Application for Planning Permission

Development: Proposed external alteration including introduction of a new accessible ramp and steps to the main entrance, new external light and alteration of the existing paths. This application may affect the setting of a listed building and is in CIL Zone 4 (Zero Rated) as other development.

Location: Holy Cross Church Chichester Road Bersted PO21 5AU

Drawing Title:  
**As Proposed  
Elevations**

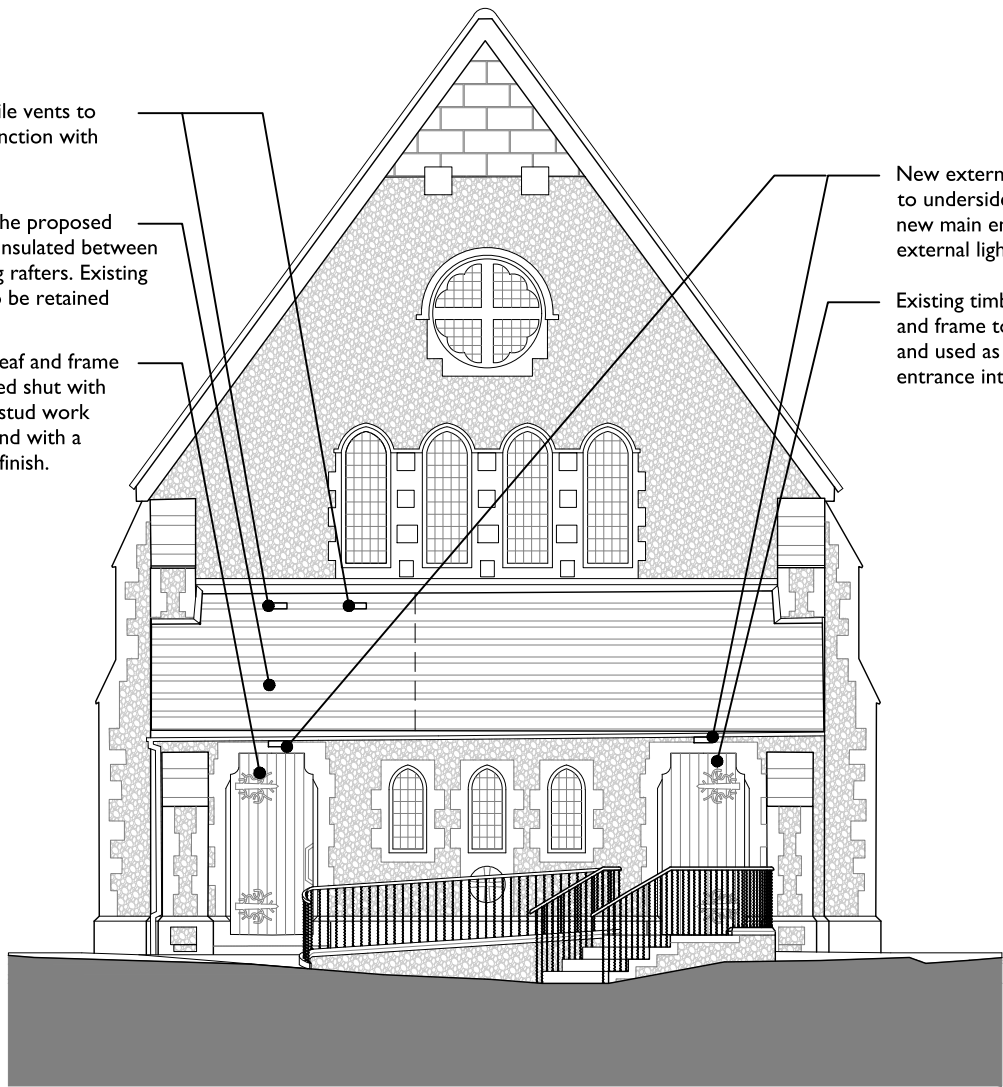
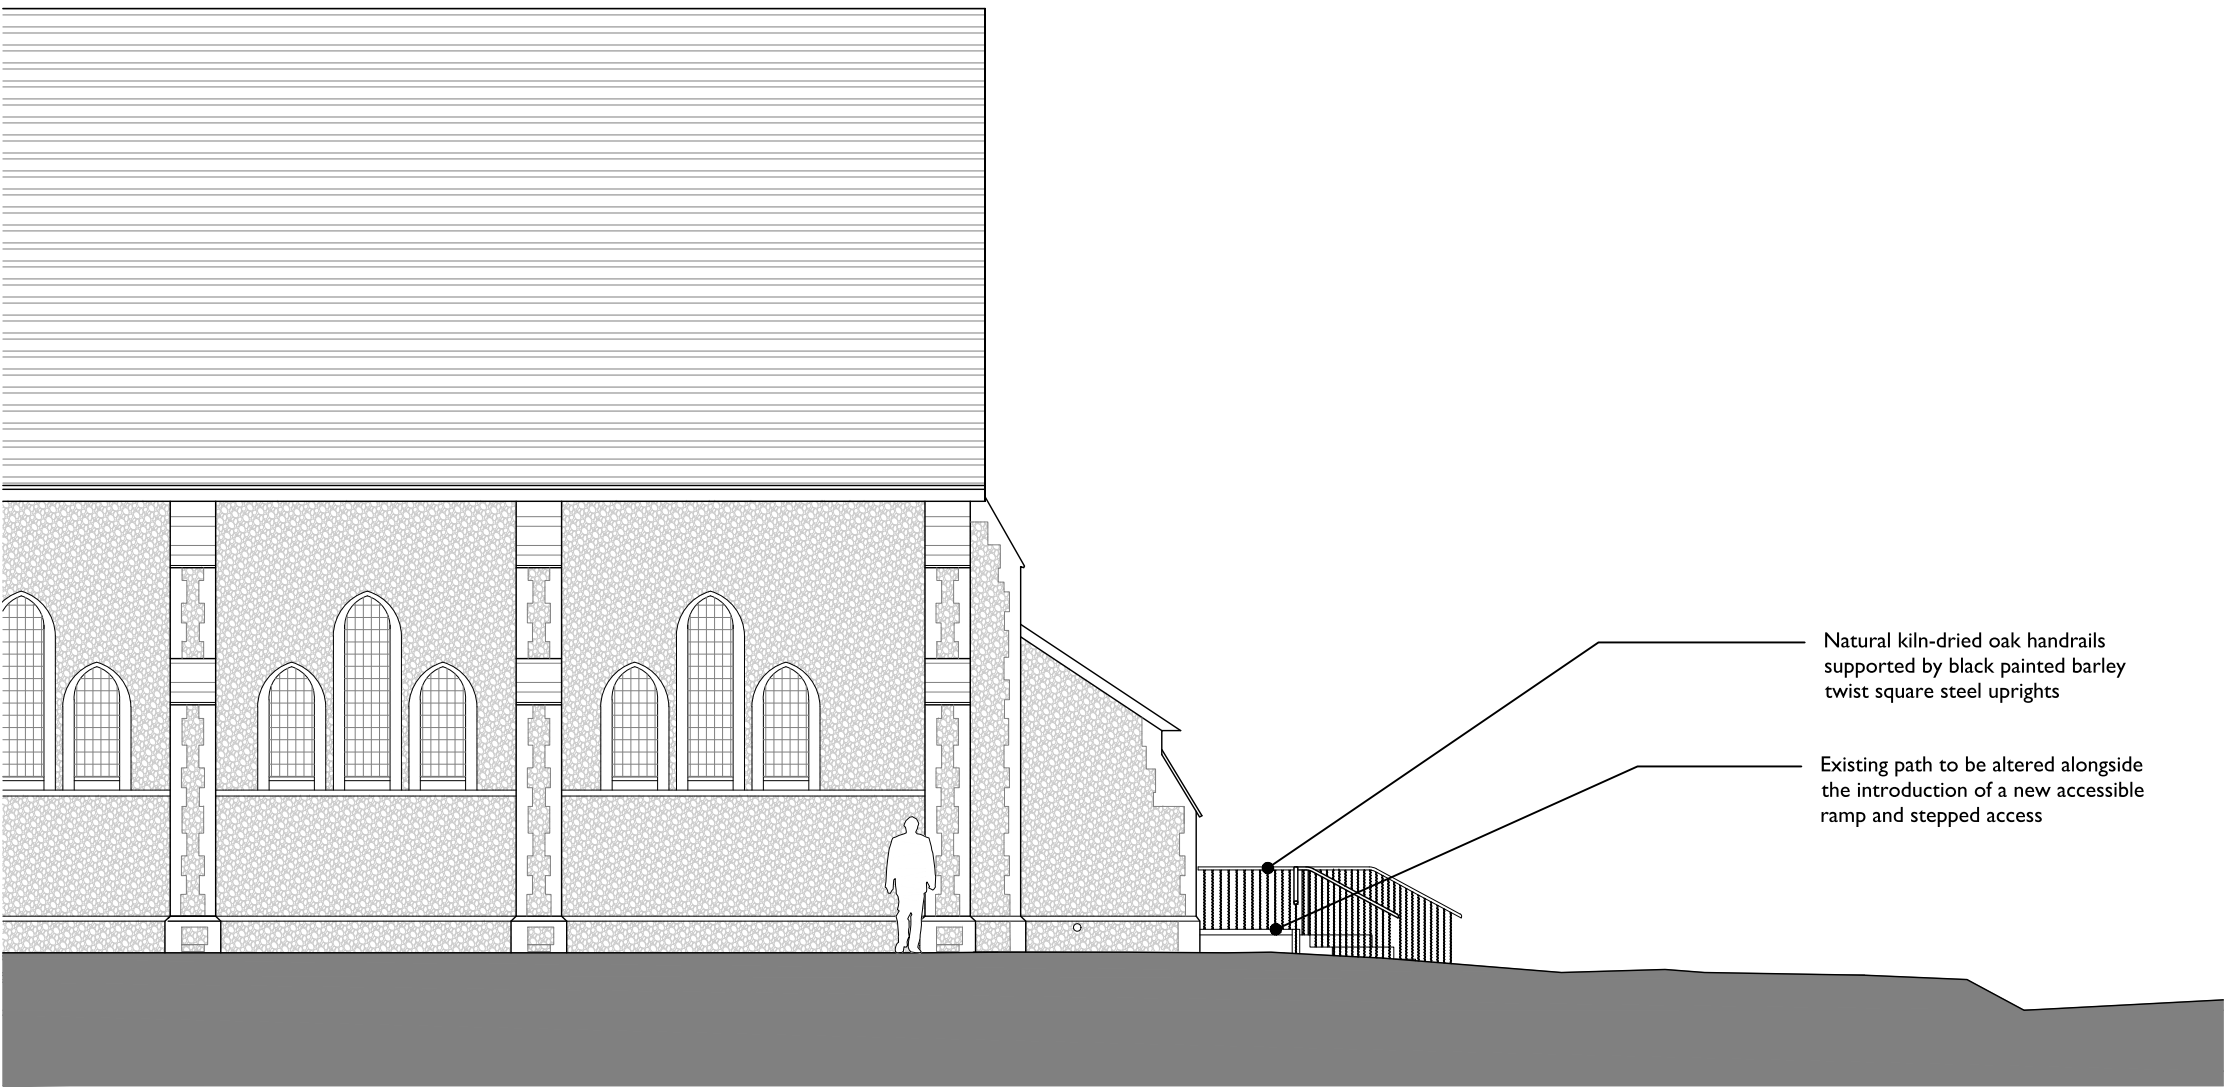
Please show the position of the proposed lights on either the proposed site plan or the proposed ground floor plan.
